REF: 22/01144/F

Location: OS Parcel 5700 South West Of Grange Farm

Holding objection

25 May 2022

AREA SCHEDULE:

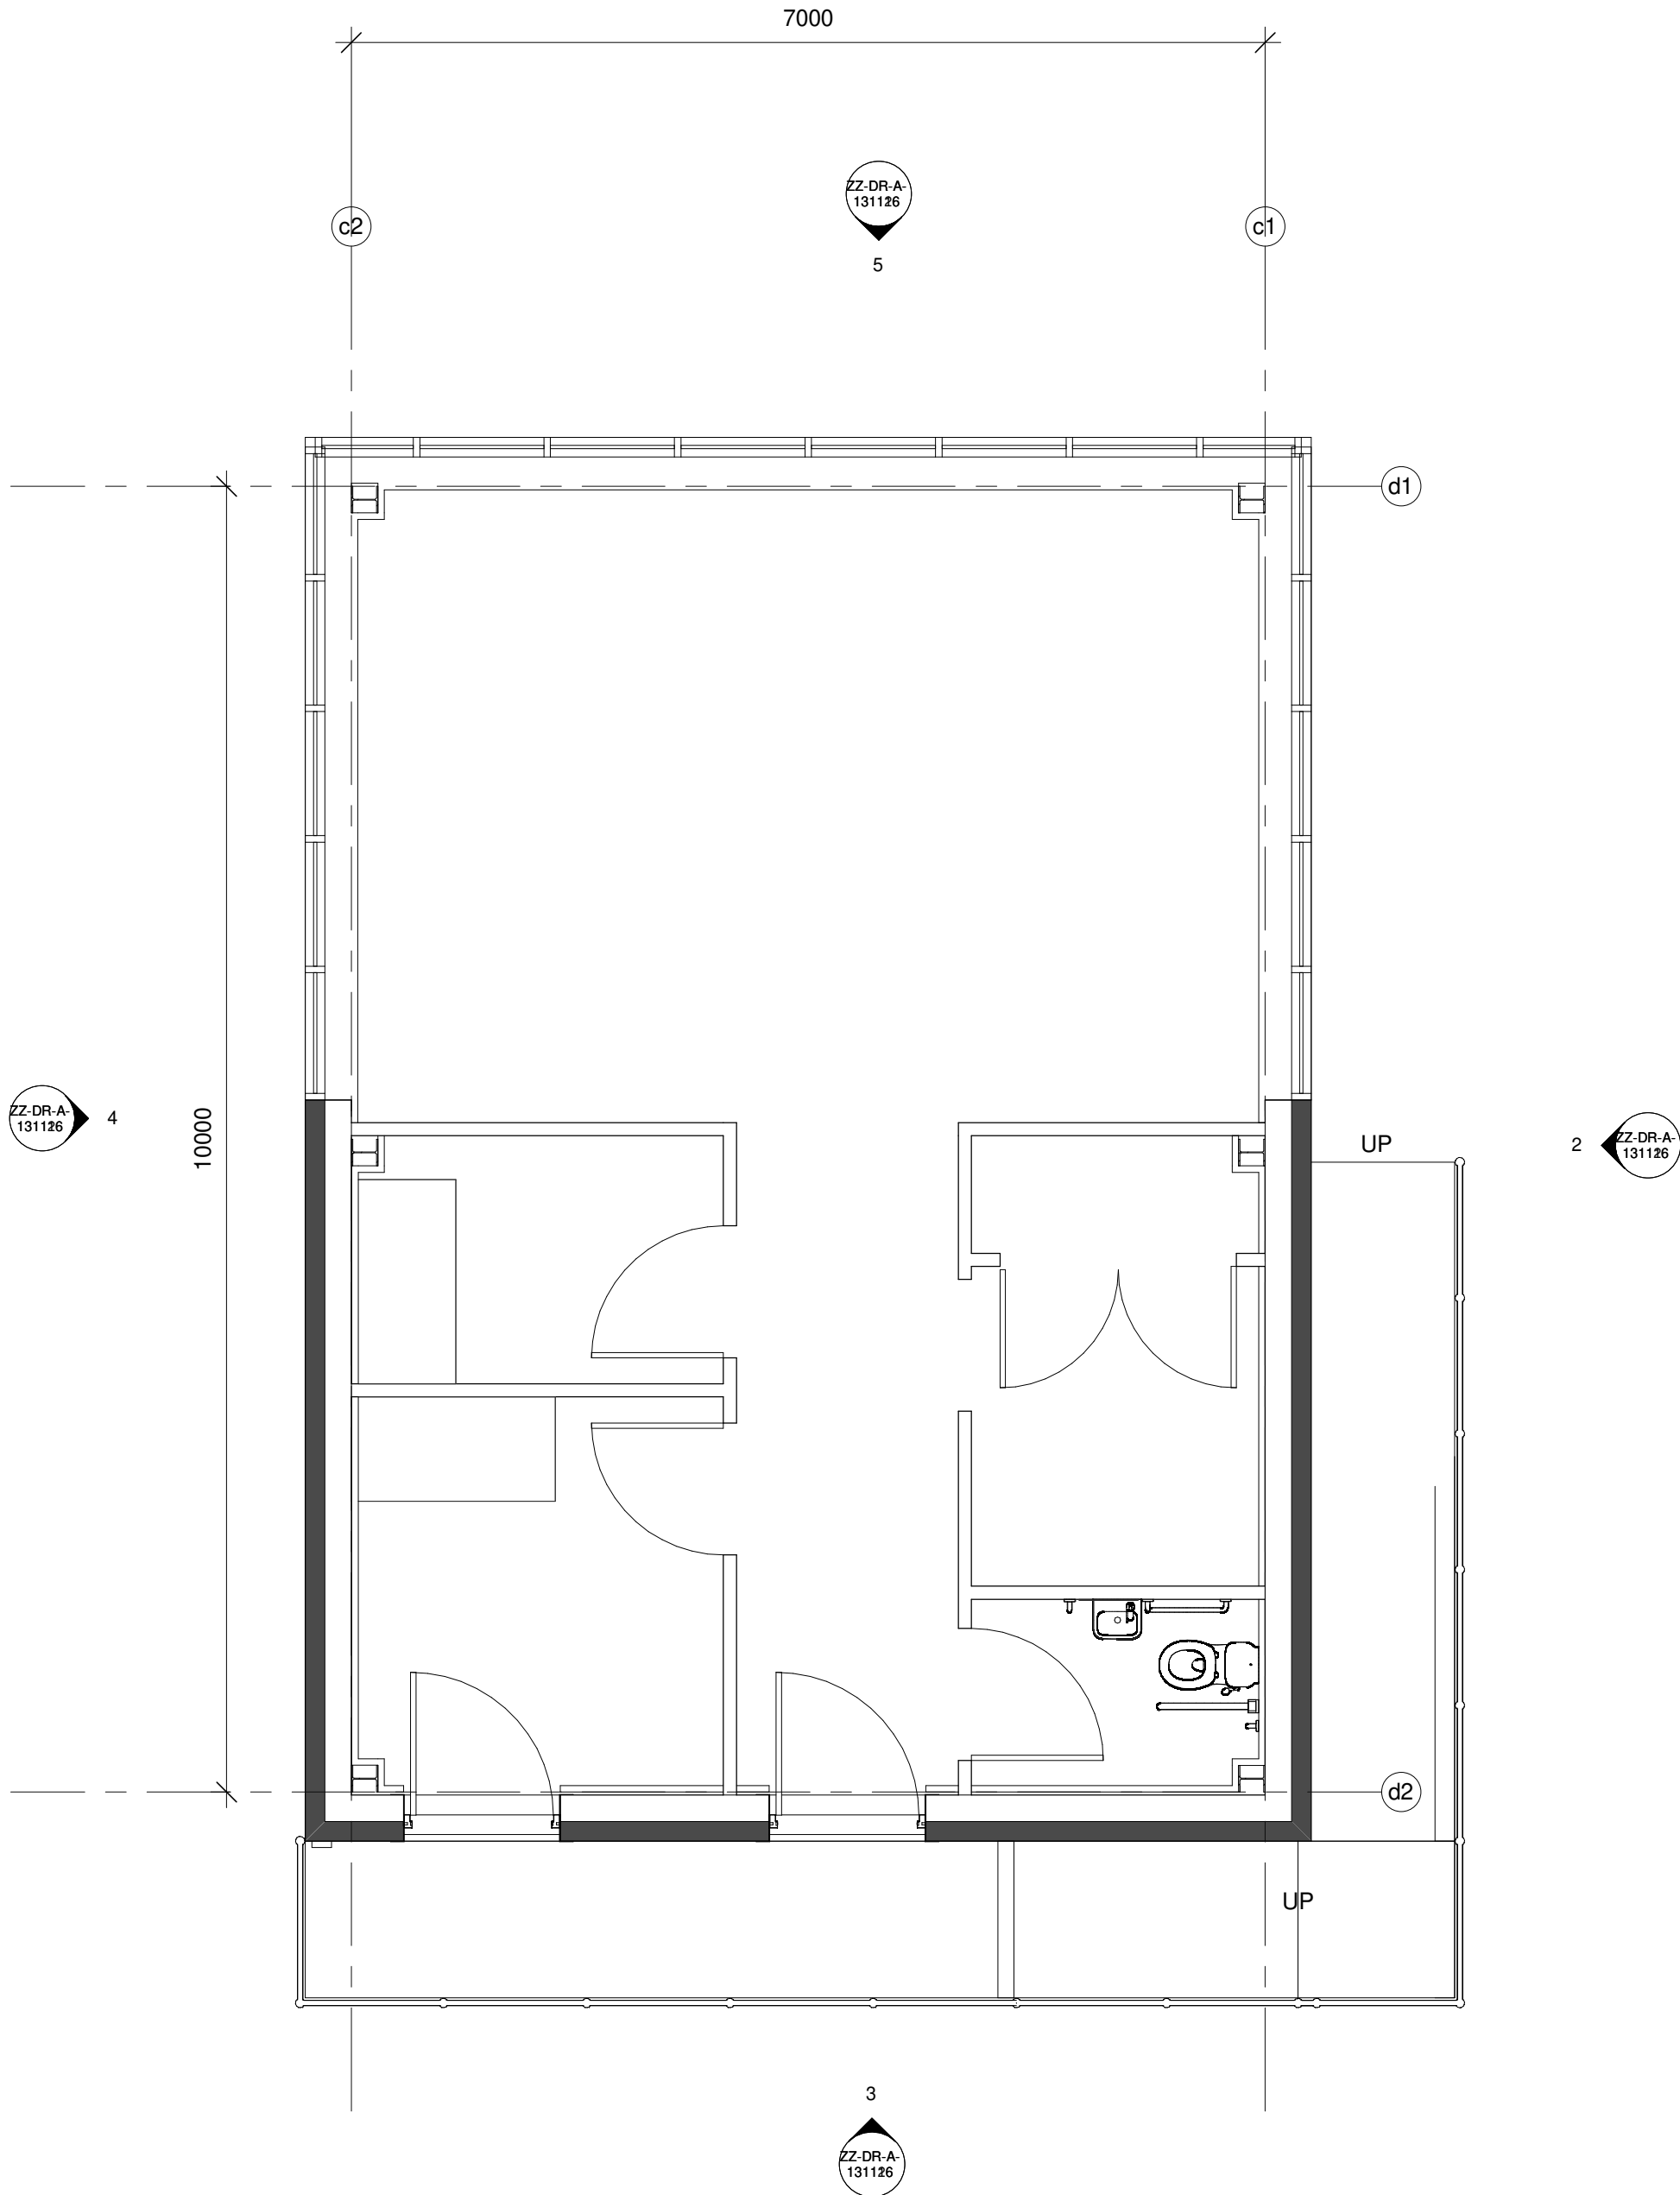
- I recommend the entry point to the site for vehicles and pedestrians is located alongside the gatehouse to provide additional surveillance and security over vehicular and pedestrian movements to and from the site.
- Formal surveillance (CCTV) should be provided and must be designed holistically in conjunction with lighting and landscaping to avoid areas of pooling or shadowing of light which could compromise the effectiveness of the system. CCTV installations should be certificated to the requirements of BS EN 50132-7: 2012+A1:2013. An operational requirements study should be completed to inform the location and specification of cameras around the site, and details should be submitted to the LPA and approved in writing before occupation and use of the building.
